From: [REDACTED]
Sent: 16 September 2021 17:17
To: [REDACTED]
Cc: ENC PLANNING; Julian Arrowsmith
Subject: RE: NE/21/01338/FUL - Auto Spares and Salvage Ltd, Raunds
Attachments: Autospars - Location Plan.pdf; 1856 - GA01-C PLANNING DRAWING.pdf

From: [REDACTED]
Sent: 16 September 2021 14:51
To: [REDACTED]
Cc: [REDACTED]
Subject: NE/21/01338/FUL - Auto Spares and Salvage Ltd, Raunds

**TITLE**  
 FLOOR PLANS - PLANNING DRAWING

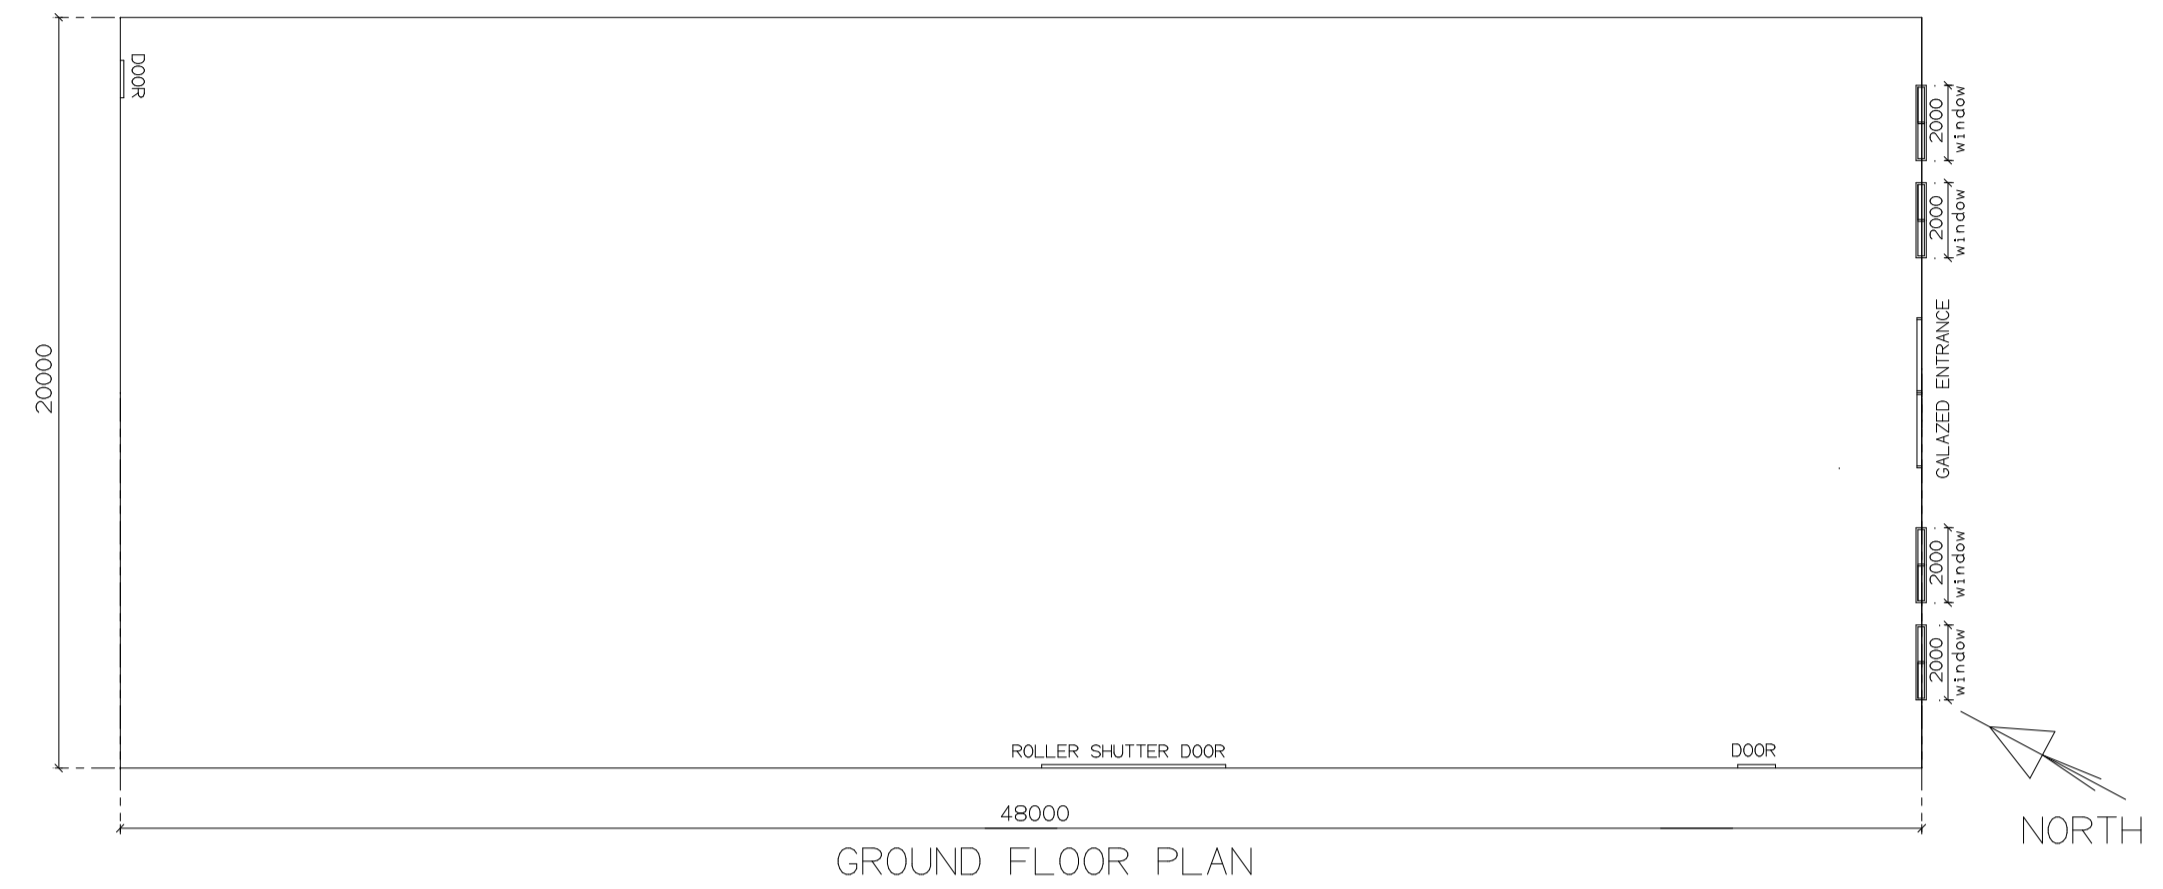
Please provide amended drawings as per listed below:

- Amended ground floor plan, first floor plan, second floor/roof plan, showing the omitted details as listed above. **Noted.**

SCALE	JOB No	DWG No.	REV
1:100	1851	GA01	C

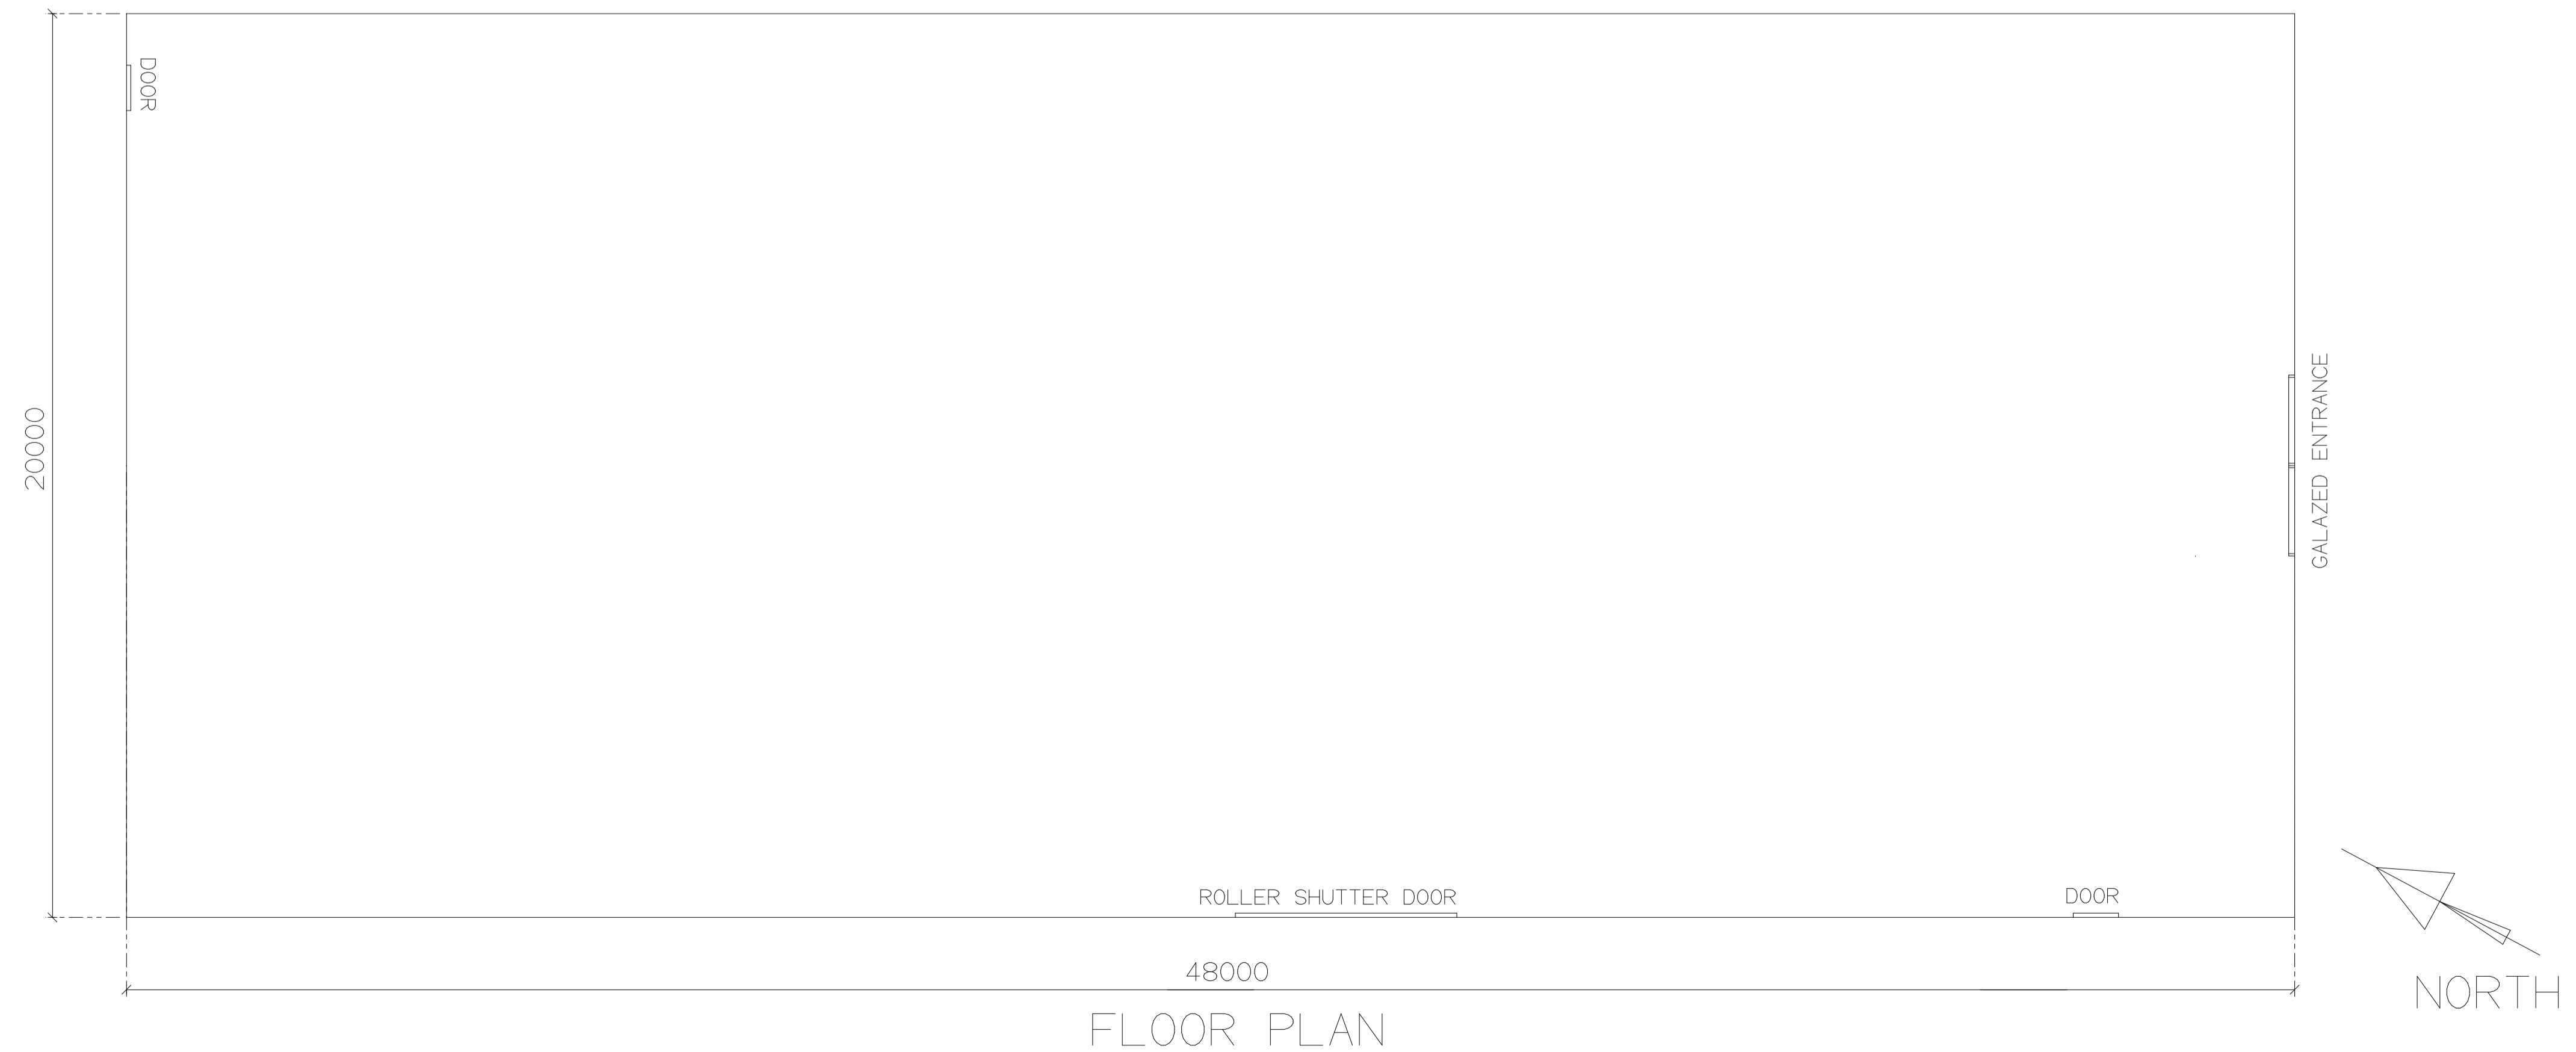
Point 1 - As previously explained in my letter these new amended drawings specifically the floor plan do not show all the windows, doors and details, you have provided the proposed ground floor plan without these details.

Please see the specific points of what has been omitted from the floor plans and provide all floor plans for each floor.

- There are windows shown on the elevation, at ground floor level either side of the glazed entrance door, along with numerous windows shown at first floor level.

- A fire escape door with stairs shown on one elevation, along with roof lights at the upper/2nd floor
- The elevation showing the roller shutter door, has a window at first floor level and roof lights at the upper/2nd floor
